April 11, 2022

**Re: Champion Xpress
5101 Lomas Blvd NE
Traffic Circulation Layout
Architect's Stamp NONE (J17-D010)**

Based upon the information provided in your submittal received 04-11-2022, the above referenced plan cannot be approved for Building Permit until the following comments are addressed:

DATE 5/11/2022	SHEET G3A
SCALE:

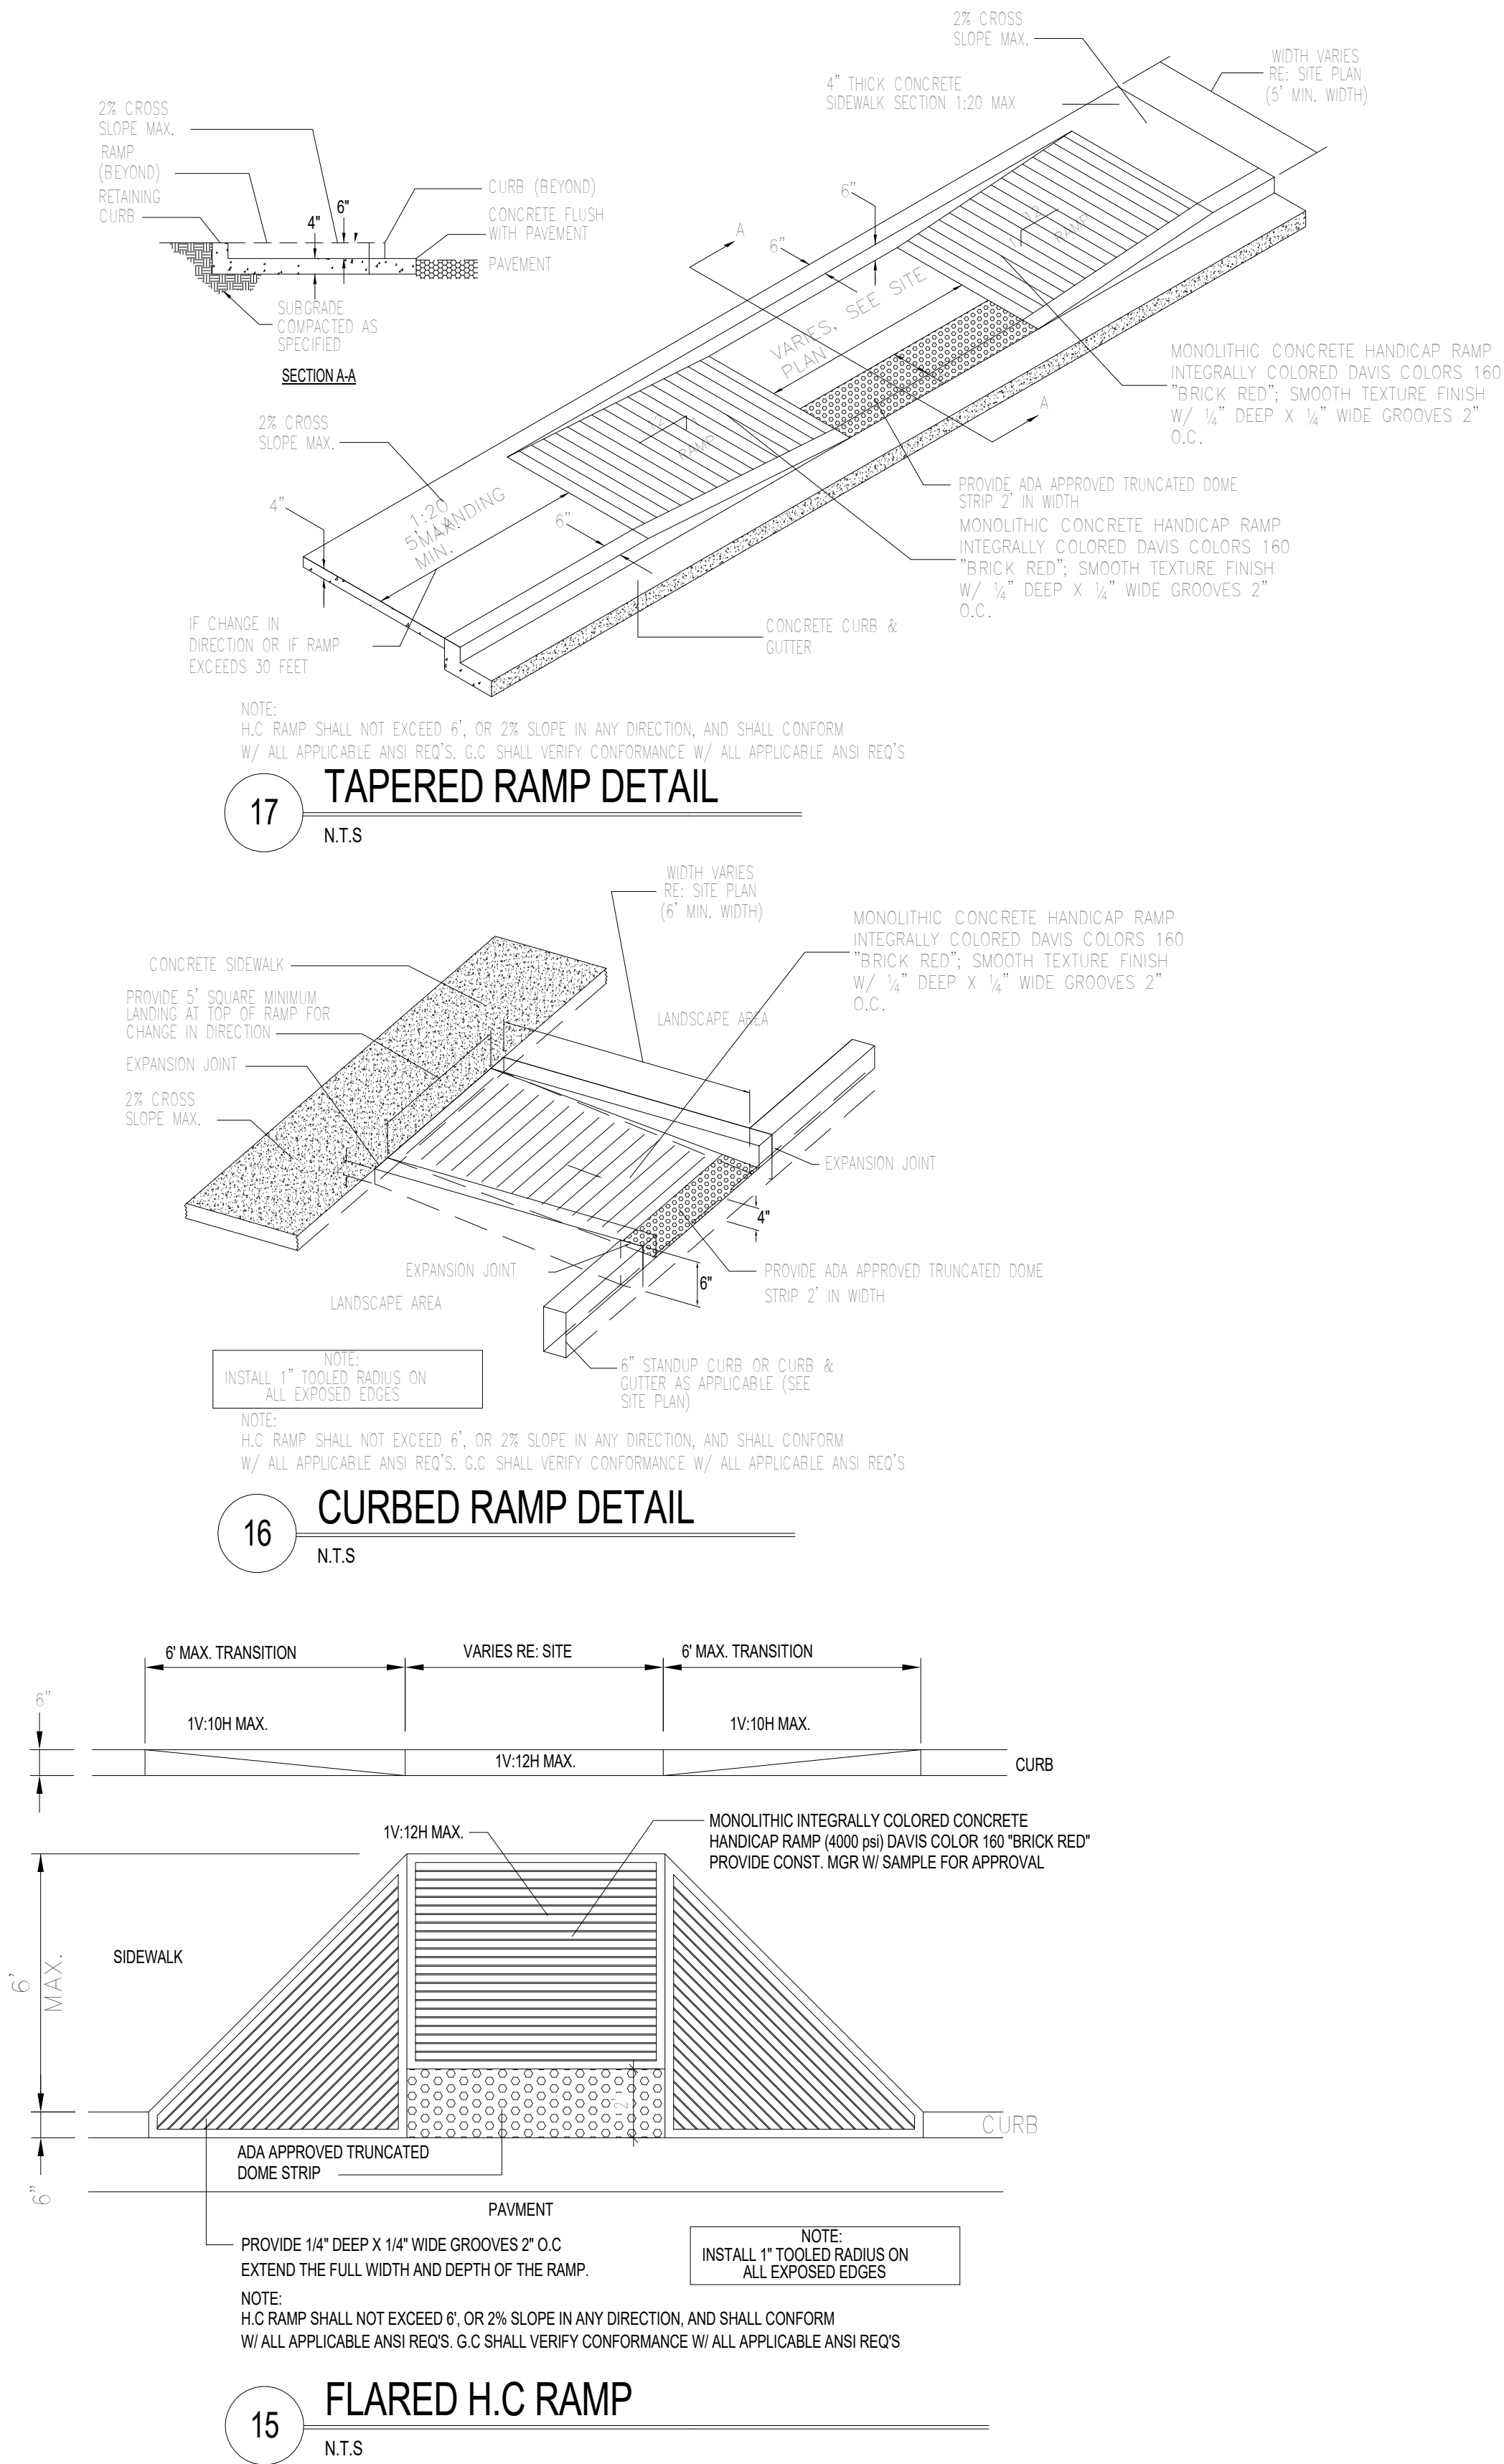
3. The traffic circulation layout must be stamped, signed, and dated by an engineer or architect licensed in the state of New Mexico.
4. **Manzano St. Frontage:**

- The northern section of existing property line will need to be shown on site plan as well as notes defining existing and proposed infrastructure.
 - ADA ramps will be needed at northern exiting driveway. Provided details.

- Solid Waste driveway will need ADA ramps and details and radii with 25 ft max.
 - Keyed Note 5 & 18 proposed signs need to be back to back.
 - Provide note to add 4 ft sidewalk (COA std dwg 2430) to the whole frontage since asphalt exists as a pathway(not allowed to be used as sidewalk).

- All proposed radiuses will need to be 12-20 ft for car usage (external).
 - Proposed signage and pavement markings ('Do Not Enter' text) needs to be located on private property and not on COA/public ROW.

5. **Lomas Blvd Frontage:**
 - Label Lomas Blvd and not Ave.
 - Corner of Lomas/Manzano: It appears that the existing ramp might not current/update ADA accessible please provide an accessible ADA ramp and details. Please verify for this existing ramp.

- Proposed entrance will need ADA ramp design and details.
 - All proposed radiuses at entrance will need to be between 22 ft & 30 ft radii's.
 - Reference COA std dwg 2426 for proposed driveway entrance versus Keyed Note 22.

- Existing Signage will need to be located outside of COA ROW or obtain a Revocable permit to continue its existing location within public ROW (partially).

6. You have shown a segment of What appears to be a pathway from Lomas to the property line on the eastern sidewalk of site adjacent to east property and no curbing provided on the northern section.

7. All internal radii's will need to be 15 ft minimum.
8. **Keyed Note 1:** Are you proposing this type of curb around the site? Why?
9. **Keyed Note 3:** The signage location will need to reflect the stall location. Please clarify.

10. **Keyed Note 24:** Detail will be needed.
11. The 5 ft pathway from Lomas to onsite appear to be in conflict with proposed ramp (Keyed Note 17) and no note has been provided to define ADA ramps across drive thru aisle. Please provide ramps and details to go along with proposed infrastructure.

12. Please identify all existing buildings, doors, structures, sidewalks, curbs, drive pads, wall and anything that influences the parking and circulation on the site.

13. Identify the right of way width, **medians**, curb cuts, and **street widths** Lomas and Manzano.
- Site Access
14. Maximum access width for arterial, collector, and local street (**Manzano**) are as follows:

16. Parallel Parking need to be 8ft x 20ft. Please adjust proposed stalls to reflect this condition.
17. The ADA accessible spaces must include an access aisle. **Van accessible aisles should be 8ft wide;** all others should be 5ft wide.

22. Show all drive aisle widths and radii (**ADA parking stall and proposed island**). Some dimensions are not shown.
23. The minimum drive aisle dimensions are shown below

24. Per the DPM, a 6 ft. wide ADA accessible pedestrian pathway is required from the public sidewalk to the building entrances. **Please clearly show this pathway and provide details.**

25. Per DPM, a 6 ft. wide ADA accessible pedestrian pathway is required from the ADA parking stall access aisles to the building entrances. **Please clearly show this pathway and provide details.**

26. All public sidewalks along streets should be placed at the property line.
27. Curbing should be installed to delineate landscape, parking, and pedestrian ways and identify points of access. **Please call out detail**

28. **Refuse vehicle maneuvering shall be contained on-site. The refuse vehicle shall not back into the public right of way.**
29. It is not apparent what type of pavement surface is being proposed. A hard driving surface will be required as part of this proposed project for parking area and drive aisles.

30. The minimum drive through lane width is 12 feet with a 25 foot minimum radius (inside edge) for all turns. (A 15 foot radius can be used with an increase in lane width to 14 feet). Please dimension all lane widths and radii.

31. Please provide a sight distance exhibit
32. Show the clear sight triangle and add the following note to the plan: "Landscaping and signage will not interfere with clear sight requirements. Therefore, signs, walls, trees, and shrubbery between 3 and 8 feet tall (as measured from the gutter pan) will not be acceptable in the clear sight triangle.

34. Unused curb cuts must be replaced with sidewalk and curb & gutter. A build note must be provided referring to the appropriate City Standard drawing (2430 & 2415A):

- Manzano St. frontage.
 - Lomas frontage.
35. Add a note stating "All broken or cracked sidewalk must be replaced with sidewalk and curb & gutter." A build note must be provided referring to the appropriate City Standard drawing (2430 & 2415A).

12 MISC. SIGNAGE
N.T.S.

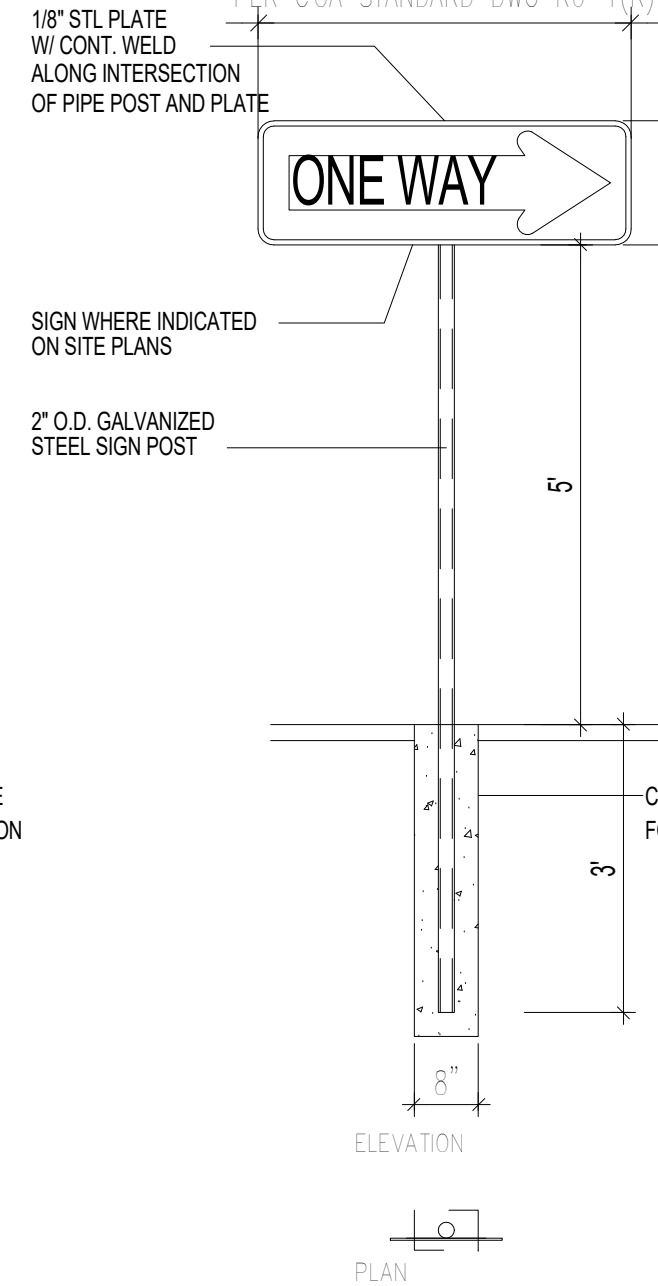
20. ADA curb ramps must be updated to current standards and have truncated domes installed (**corner of Manzano/Lomas**)
21. **Motorcycle parking space:** shall be designated by its own conspicuously posted upright sign, either free-standing or wall mounted per the zoning code. **Reference detail 12/G6 for signage detail.**

2 H.C PARKING PLAN DETAIL (VAN ACCESSIBLE)
N.T.S.

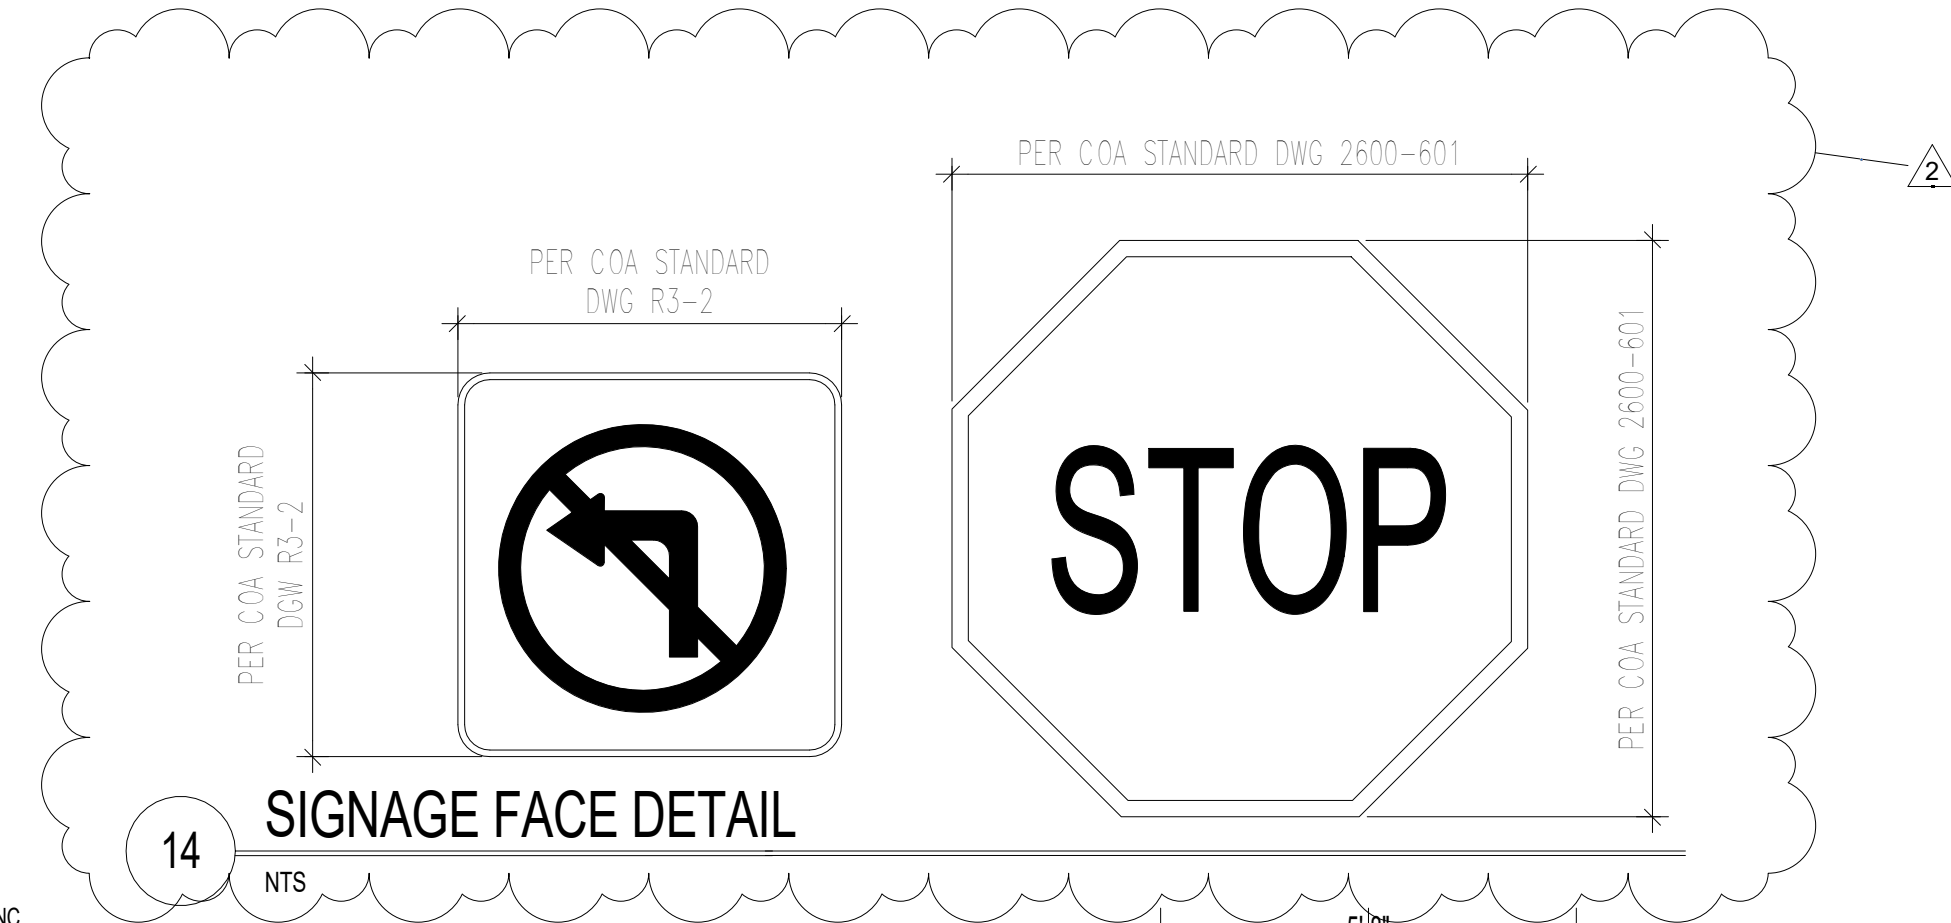
18. The proposed ADA parking stall aisle doesn't show a ramp to traverse over the curbing but you provide a detail of it on 2/G6. Please add note to site layout defining ramp.
